# CITY OF ALBUQUERQUE

RE: **Blue Linx Warehouse**  
**1820 Bellamah Ave NW**  
**Grading and Drainage Plan**  
**Engineers Stamp Date 5/26/15 (J13D101)**

**Re: Blue Linx Warehouse Adaptive Re-Use Project**  
**1820 Bellamah Ave., NW**  
**Traffic Circulation Layout**  
Engineer's/Architect's Stamp dated 5-26-15 (J13-D101)

Project no. 1407
sheet
A-1.2
5 of 34
5-26-15

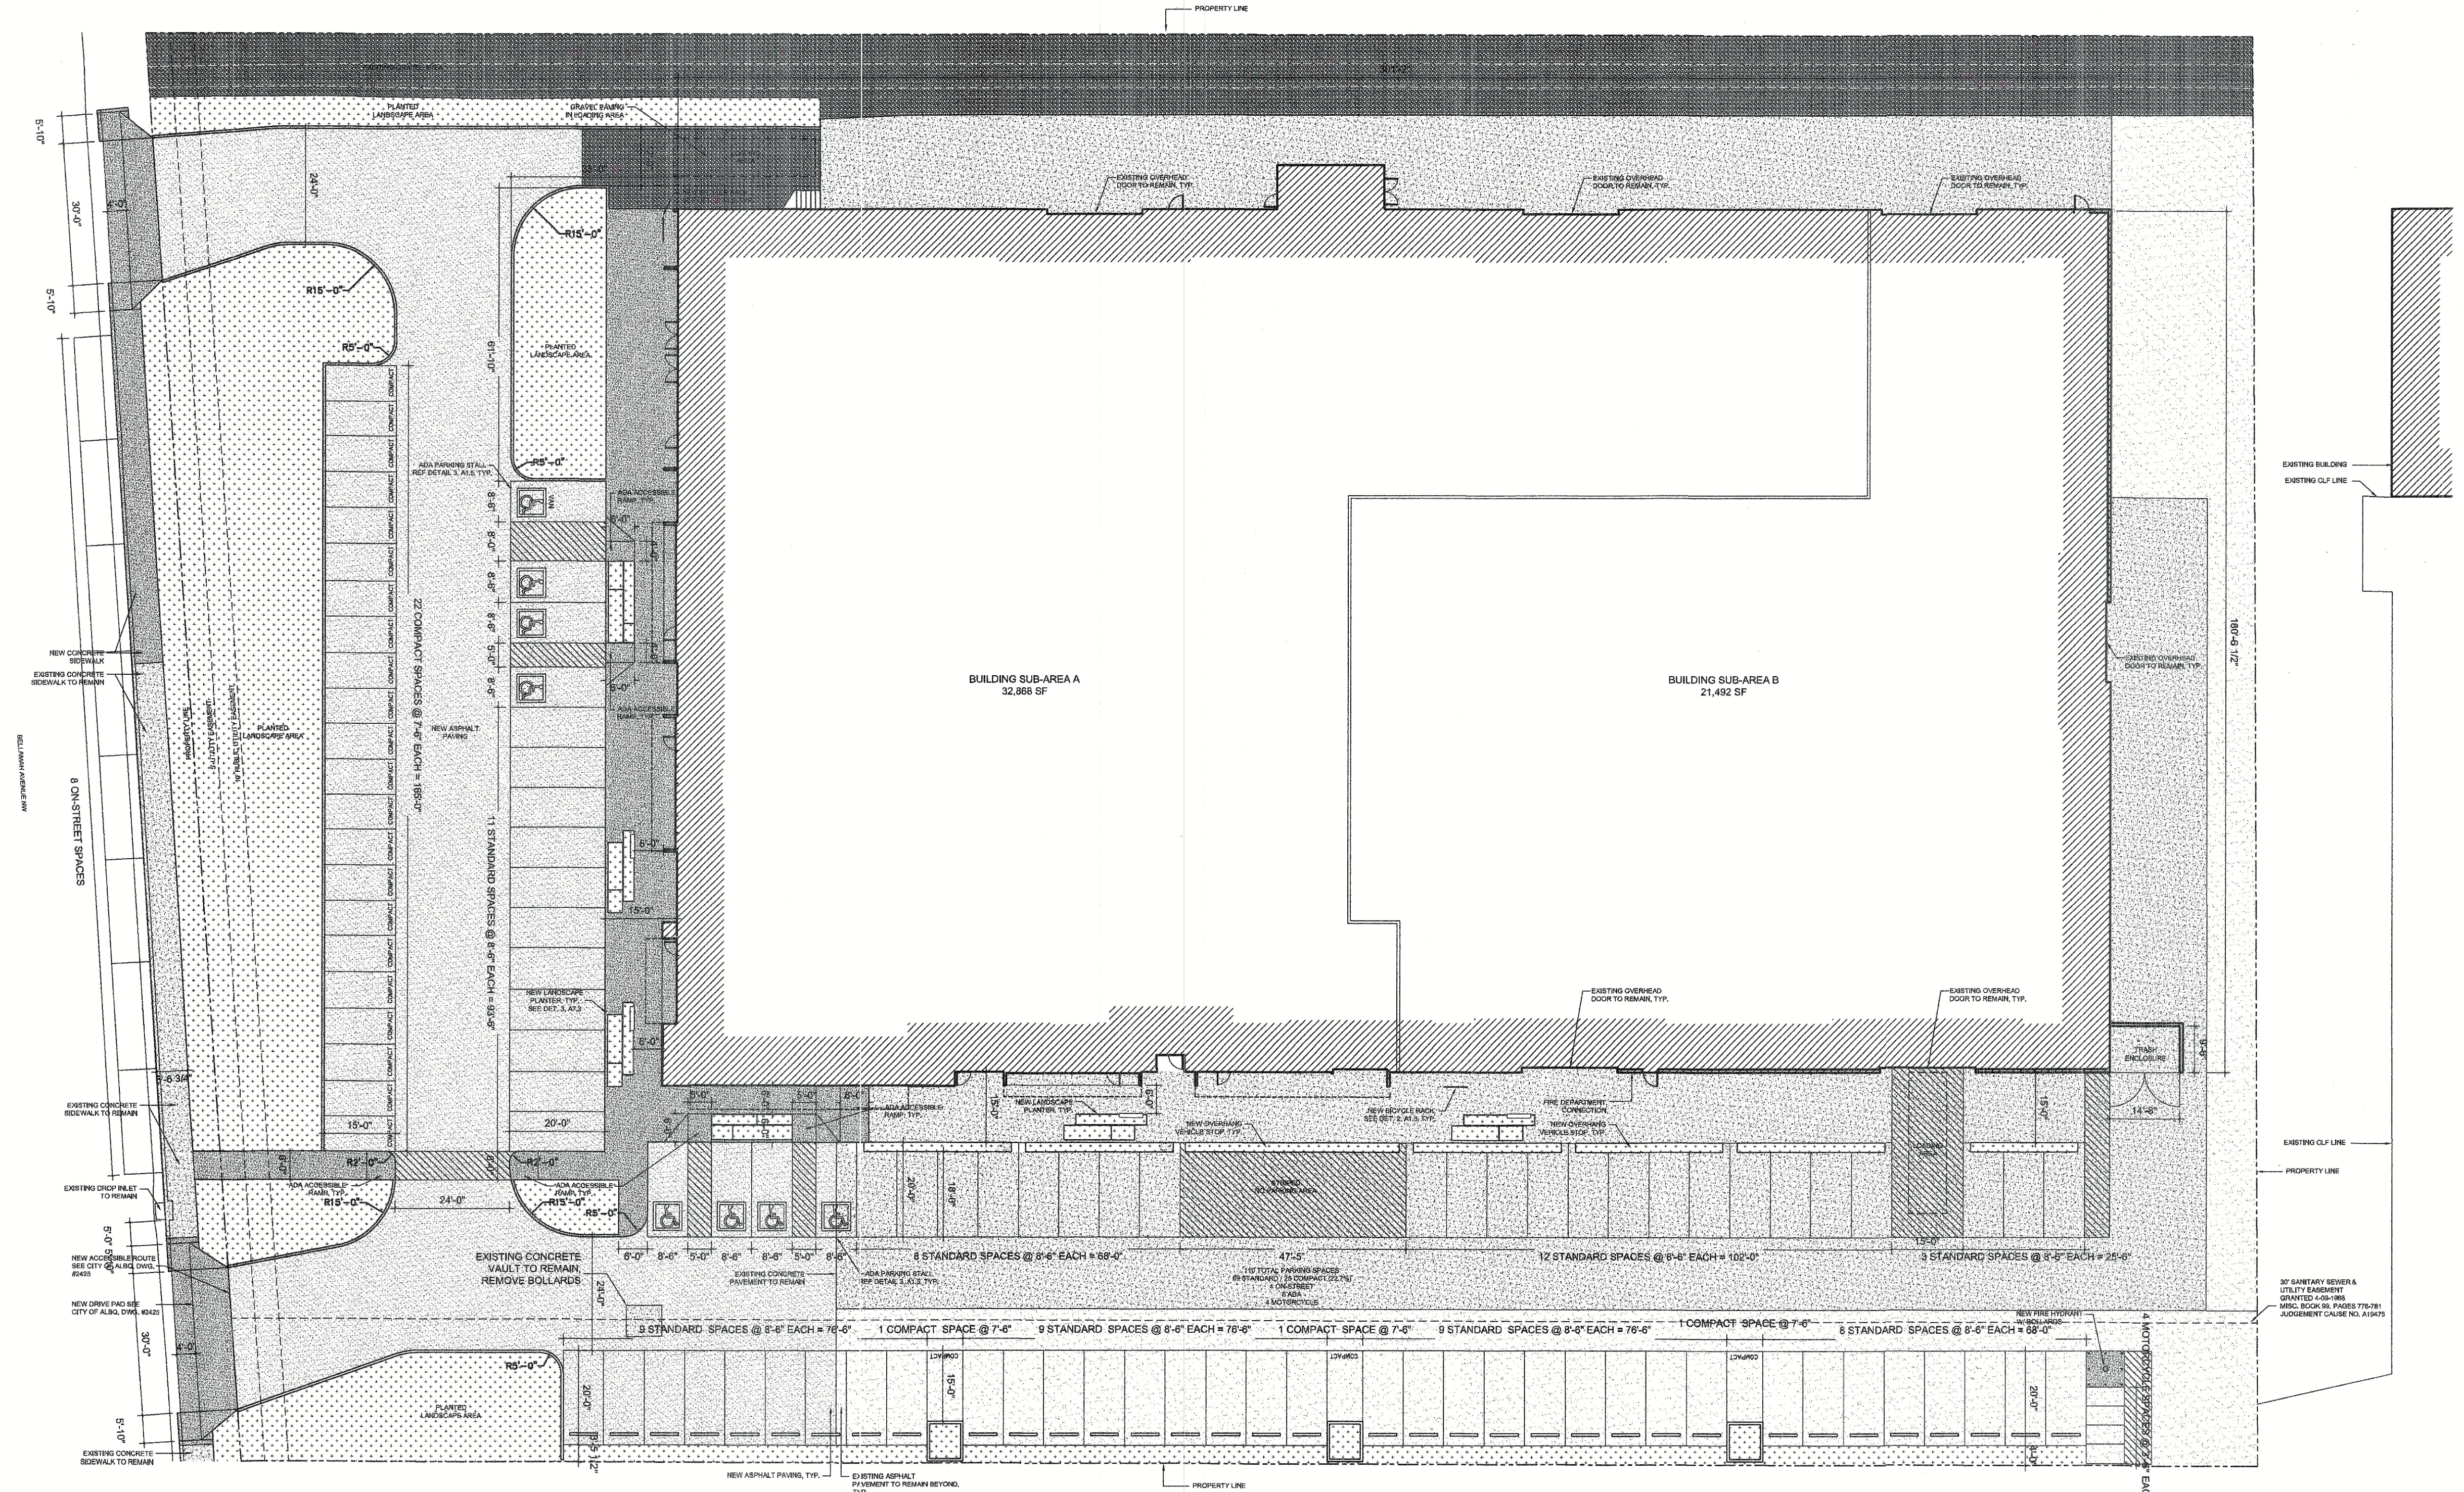
1. Identify the right of way width, medians, curb cuts, and street widths on Bellemah Ave., 18<sup>th</sup> St. and 19<sup>th</sup> St.
2. Please detail "Overhang Vehicle Stops" on west side of building and call out Turn Down Edge bumper stops on north side of building.

3. Please refer to the Fire Marshall regarding parking space in front of Fire Department Connection point, stripping might be required.
4. The ADA accessible sign must have the required language per 66-7-352.4C NMSA 1978 **"Violators Are Subject to a Fine and/or Towing."**

5. The ADA access aisle shall have the words **"NO PARKING"** in capital letters, each of which shall be at least one foot high and at least two inches wide, placed at the rear of the parking space so as to be close to where an adjacent vehicle's rear tire would be placed. (66-1-4.1.B NMSA 1978)

6. Please detail and dimension ADA ramps from handicap parking to building entrances on north and west sides of the building.
7. Provide a min 6" or max 8" high concrete barrier curb or other acceptable barrier between landscaping and parking areas and/or drive aisles. Please call out barrier curb, turndown edge and overhang wheel stop locations.

8. Design delivery vehicle route needs to be shown.
9. Service vehicle and/or refuse vehicle maneuvering must be contained on-site; provide a copy of refuse approval.

10. Please provide a sight distance exhibit (see the *Development Process Manual*, Chapter 23, Section 3, Part D.5 *Intersection Sight Distance*). Please show this detail for both the entrances on Bellamah Ave.

11. Please add the following note to the clear sight triangle: "Landscaping and signage will not interfere with clear sight requirements. Therefore, signs, walls, trees, and shrubbery between 3 and 8 feet tall (as measured from the gutter pan) will not be acceptable in this area."
12. Please include two copies of the traffic circulation layout at the next submittal.

Project no. 1407
sheet
A-1.2
4 of 25
date 1-15-16

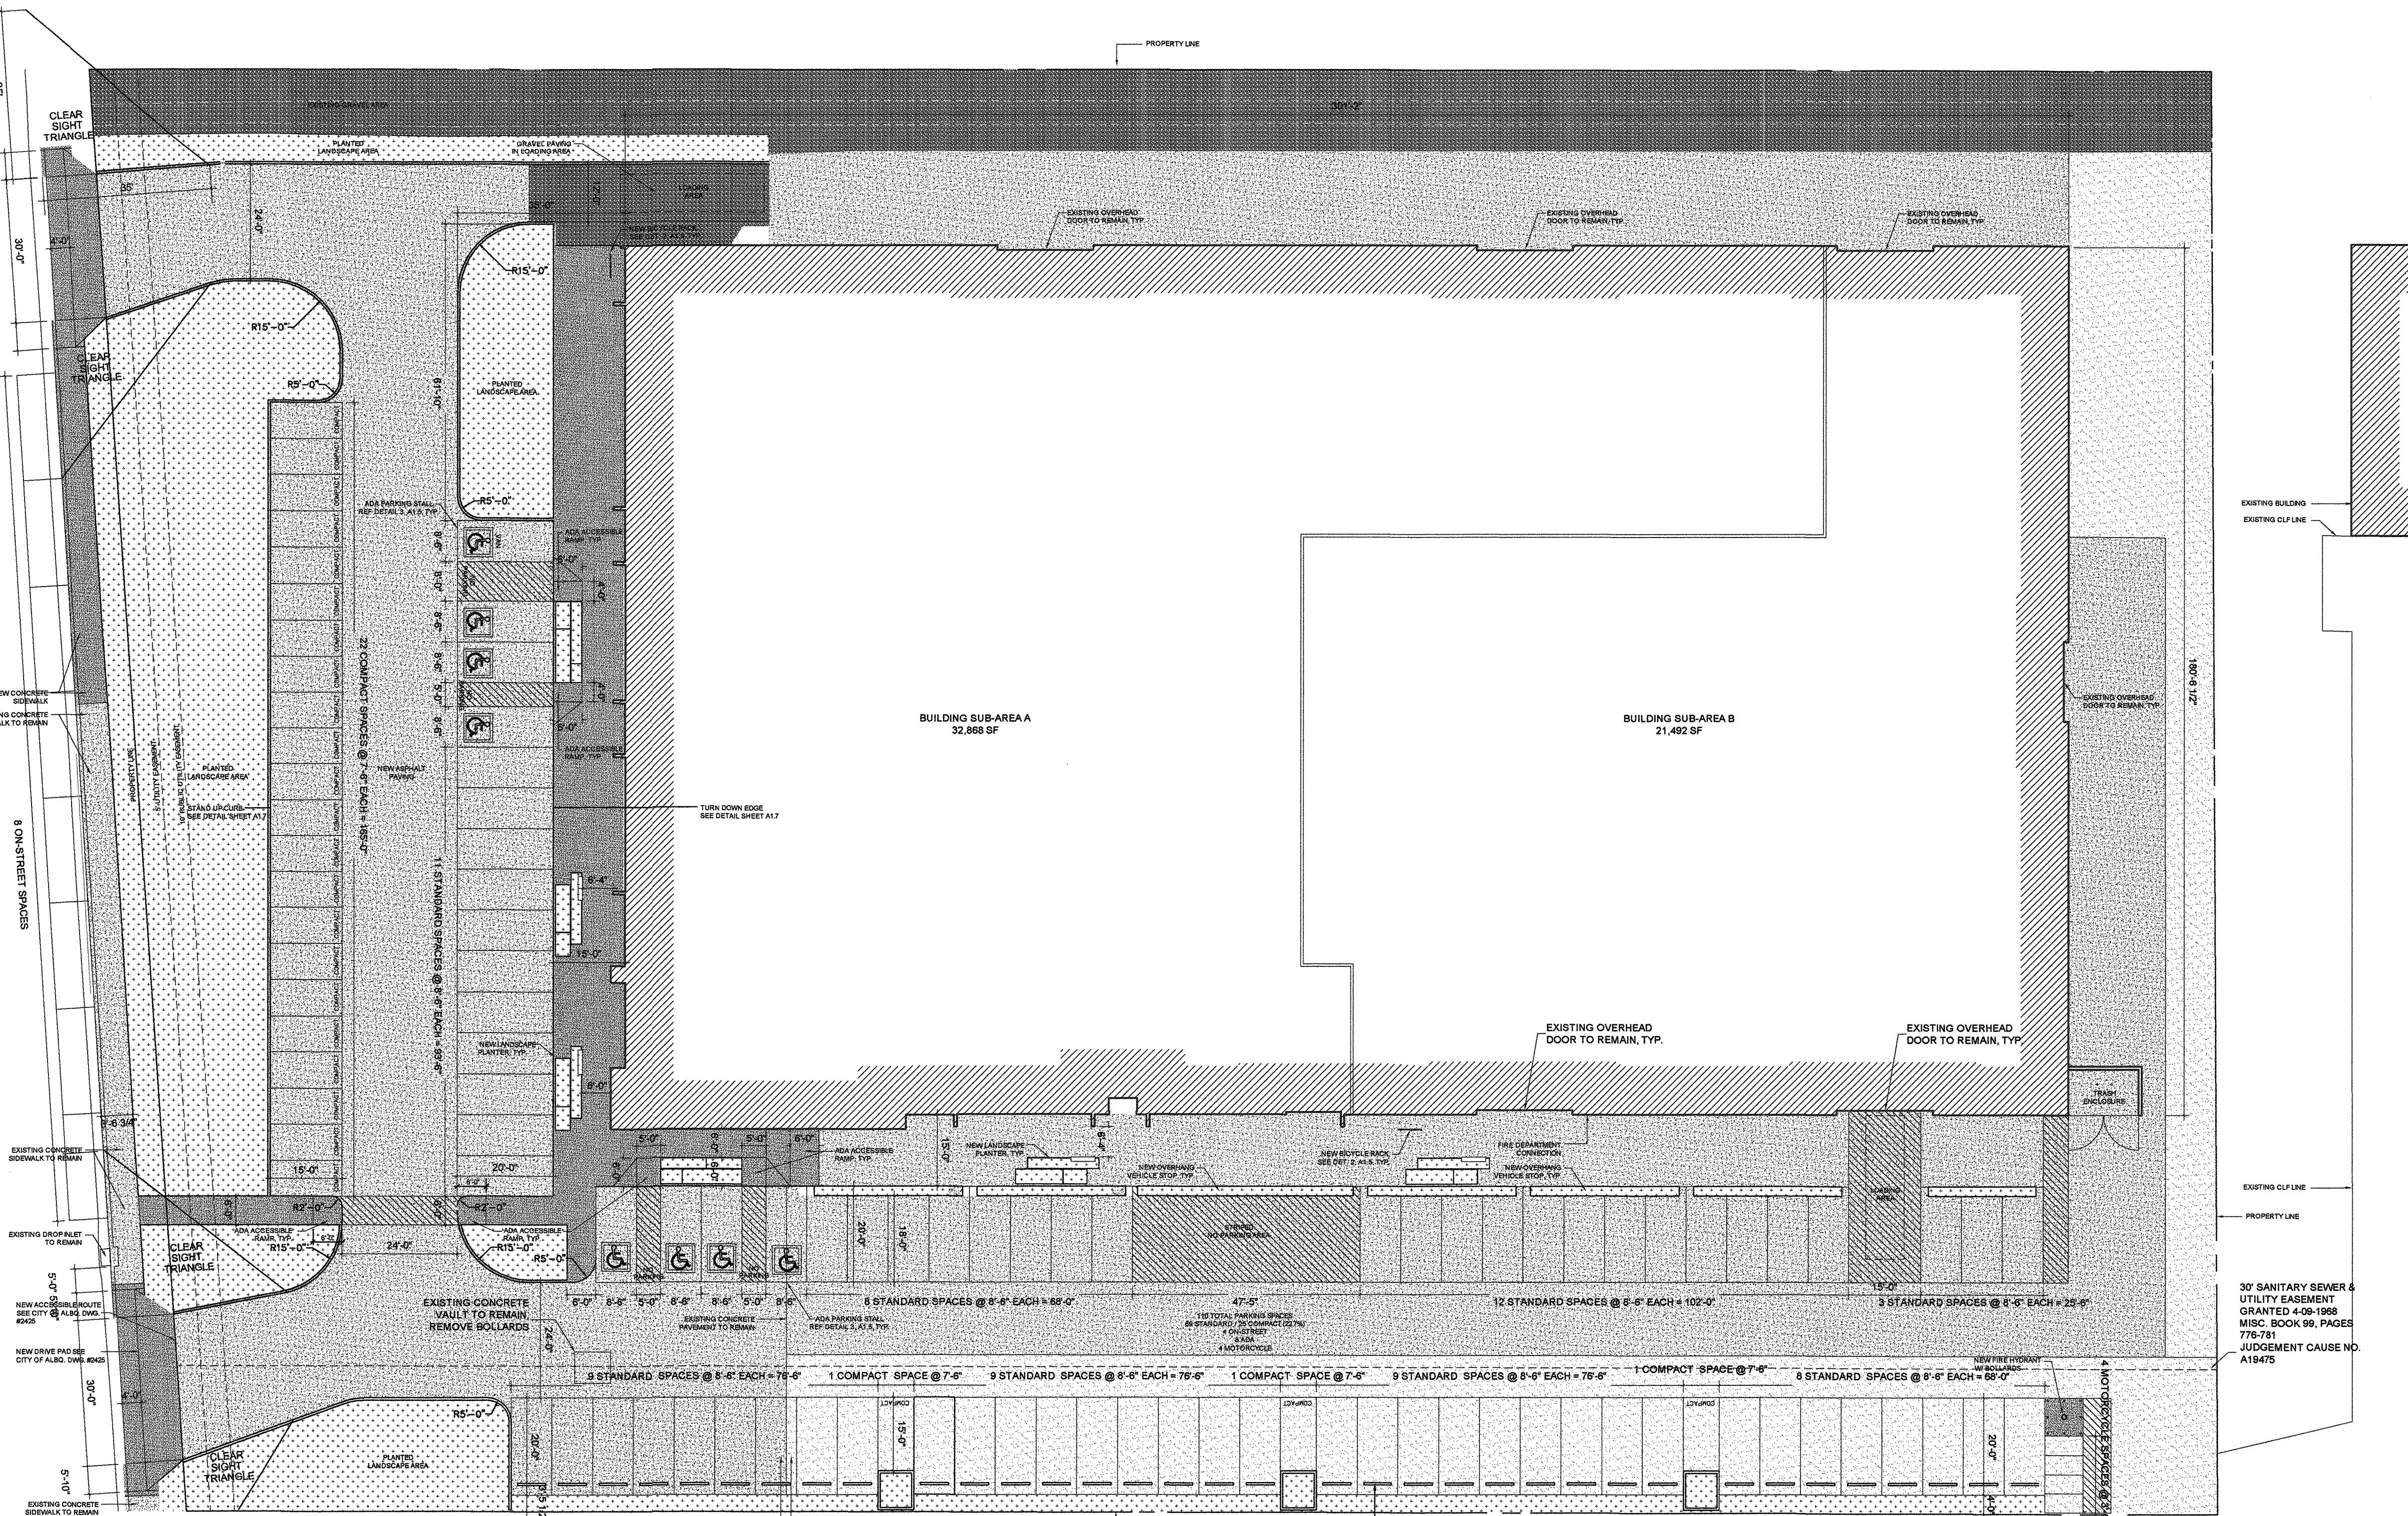
1. Compact parking spaces must be a minimal of 8 ft. in width by 15 ft. in length per COA Compressive Code. In review of the submitted drawing, all compact spaces are dimensioned to be 7.5 ft. by 15ft. Please show detail of reconfigured compact space on new submittal.

2. List the number of parking spaces required by the zoning code as well as the proposed number of parking spaces. Please state the parking calculations with revised count for compact spaces.

3. Identify the right of way width, medians, curb cuts, and street widths on 18<sup>th</sup> and 19<sup>th</sup> St.
4. Per Fire Marshall, a fire line access isle will be required in front of the AFD connection point on the west side of the building.

5. Please identify and dimension all existing and proposed sidewalks, pedestrian walkways and entrances to existing building. Note that hatch details make review of dimension difficult, if detail is too dark to read underlying dimensions.

6. Please detail and dimension all existing handicap ramps on public right-of-way and drive pads.
7. Please provide a detail of ADA access ramps to building entrances.

8. Per the DPM, a 6 ft. wide ADA accessible pedestrian pathway is required from the public sidewalk to the building entrances. Please clearly show this pathway and provide details. In review of submittal drawing, new ADA accessible route is noted to be located in the drive pad, which is not in compliance to ADA requirements.

9. Provide a min 6" or max 8" high concrete barrier curb or other acceptable barrier between landscaping and parking areas and/or drive aisles. Please call out this detail.

10. Design delivery vehicle route needs to be shown.
11. Service vehicle and/or refuse vehicle maneuvering must be contained on-site; provide a copy of refuse approval.
12. All broken or cracked sidewalk must be replaced with sidewalk and curb & gutter. A build note must be provided referring to the appropriate City Standard drawing.
13. Please include two copies of the traffic circulation layout at the next submittal.
